**Consultation Response from KC,
Trees**

2024/93502 Denelands Farm, 74, Wakefield Road, Grange Moor, Huddersfield, WF4 4BG

Formation of new vehicular access

Date Responded: 21.01.25

Drawing Title:  
**Tree Impact Plan**

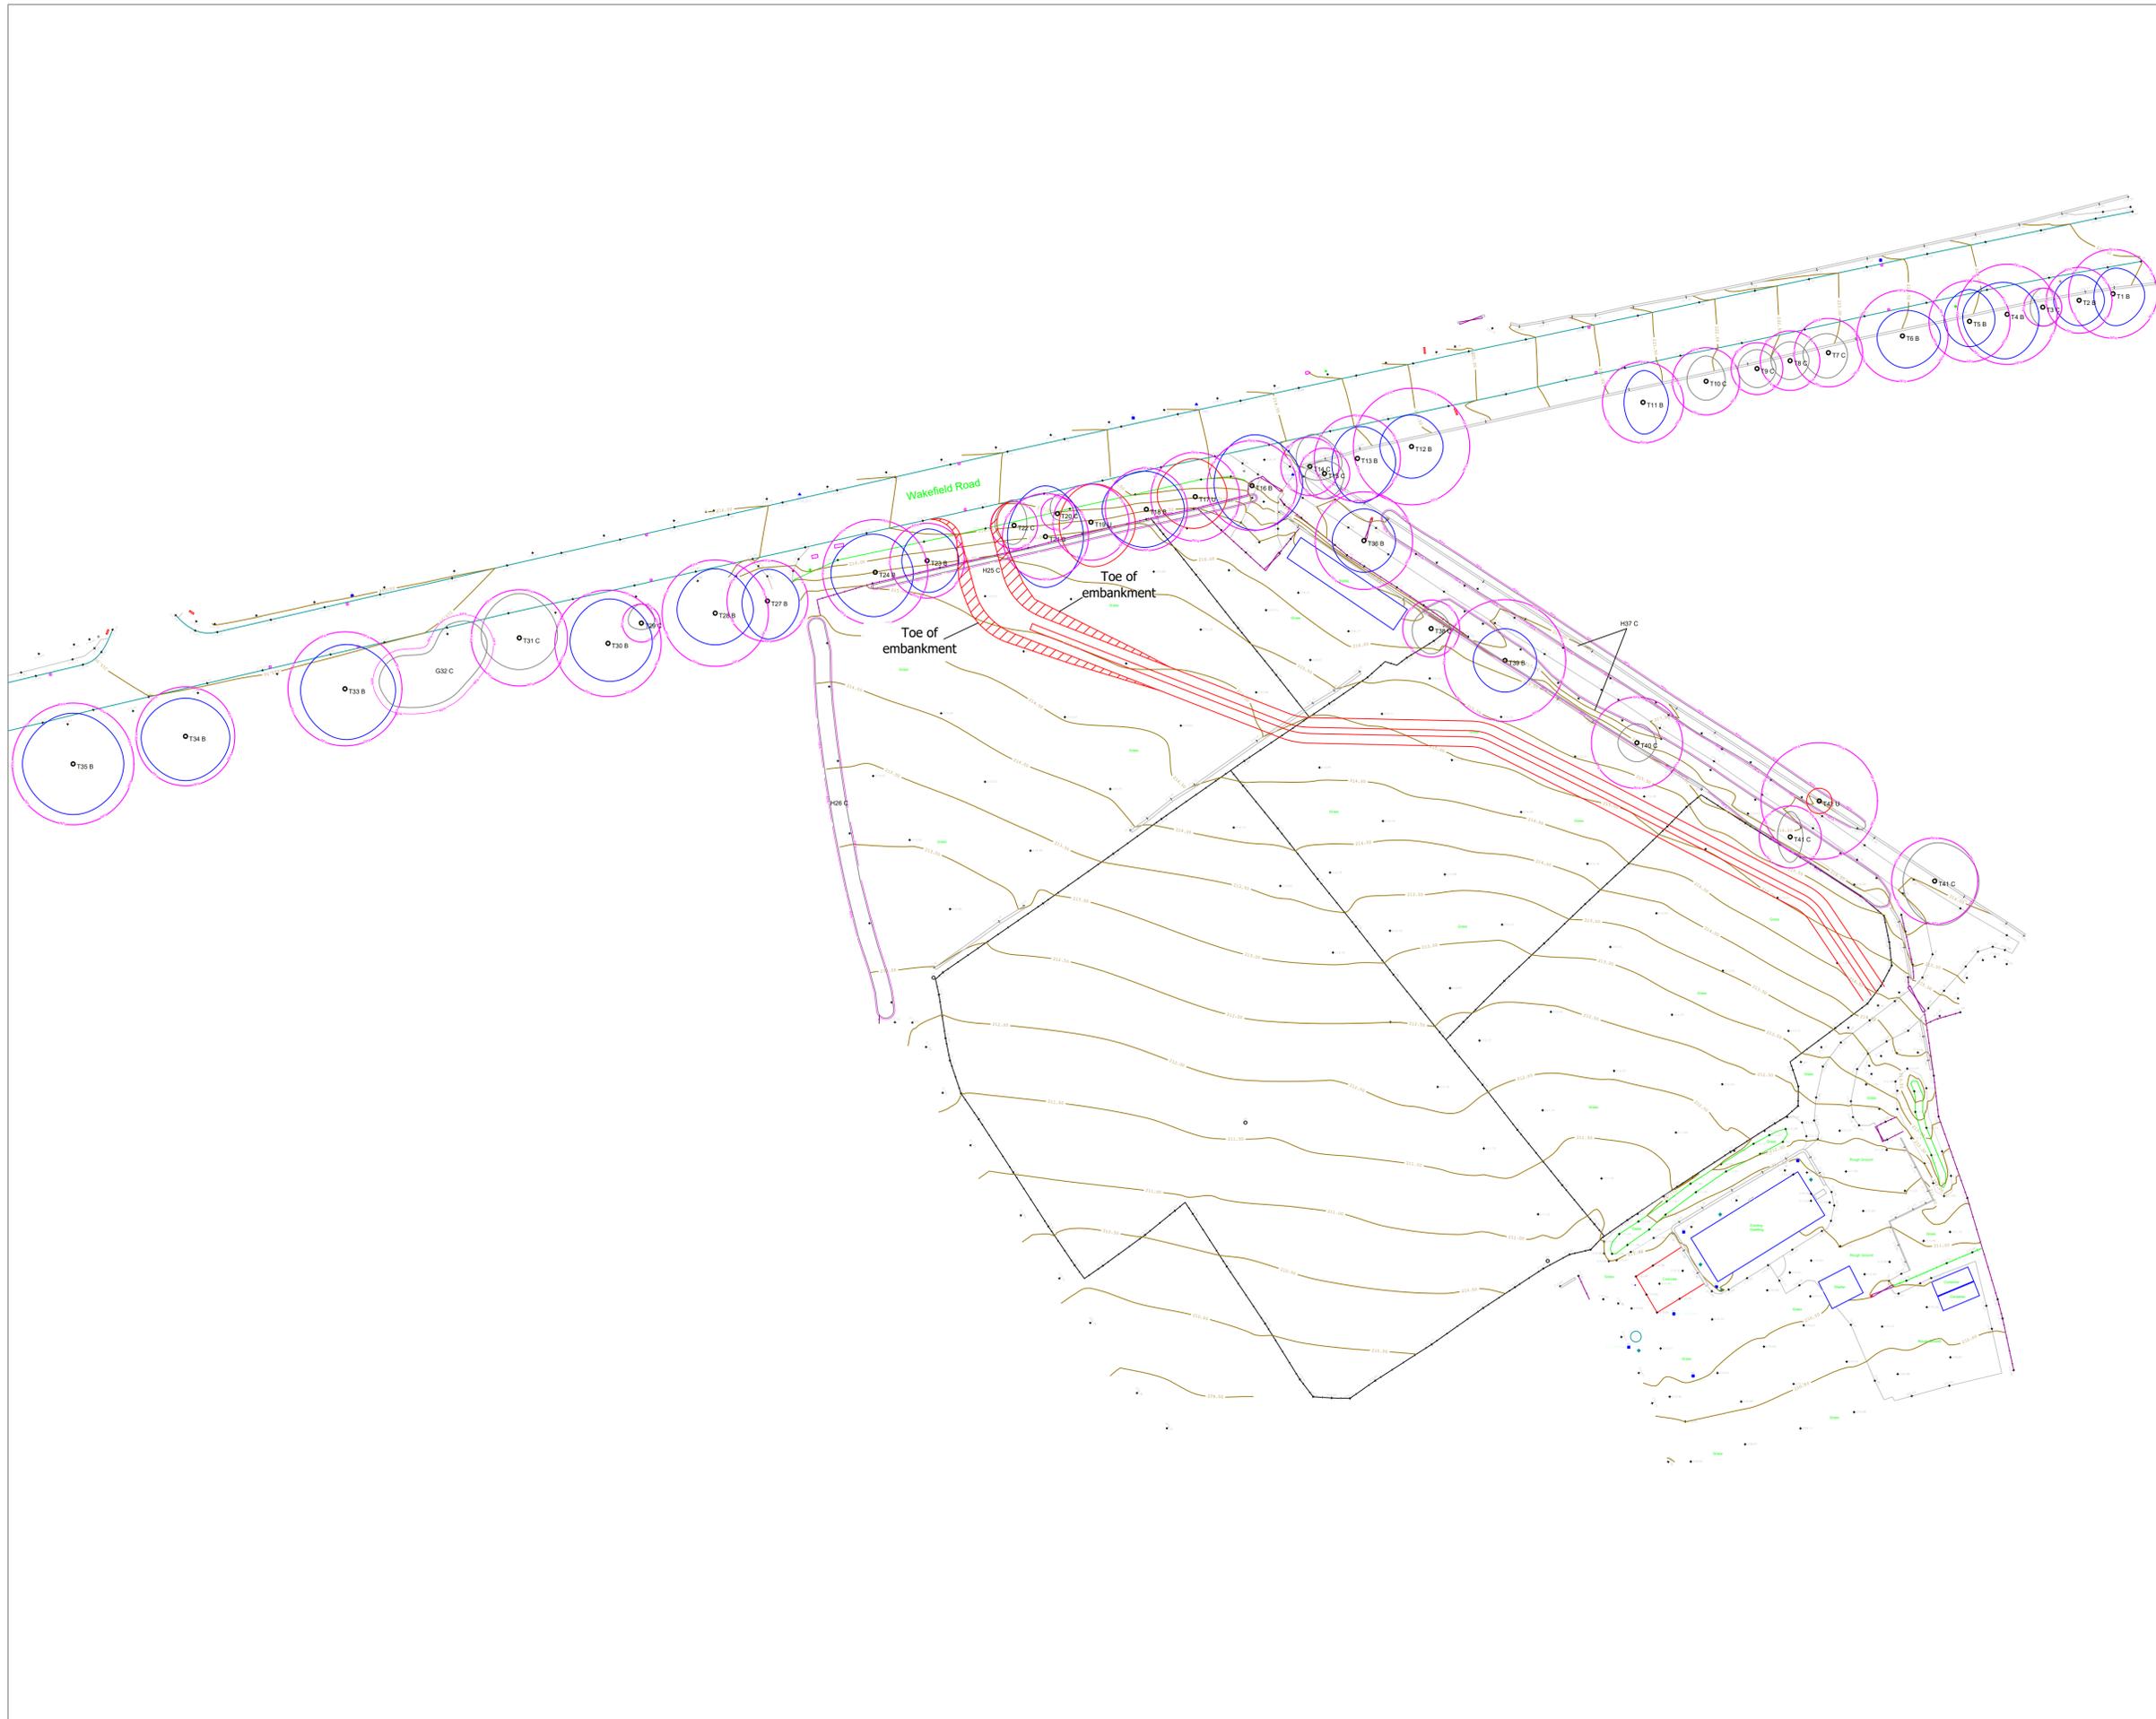
However, upon reviewing the tree impact plan, it appears ground level changes are proposed within the RPAs of Category B tree T29 and Category C tree T22. This has implications for the safe retention of these trees, as changes to the rooting environment can negatively impact the health of retained trees and machinery would need to pass within the canopies to carry out the ground works, which can lead to accidental damage to branches and stems.

There is a holding objection from an arboricultural perspective. An AMS is conditioned to demonstrate how the retained trees will be protected from the development.
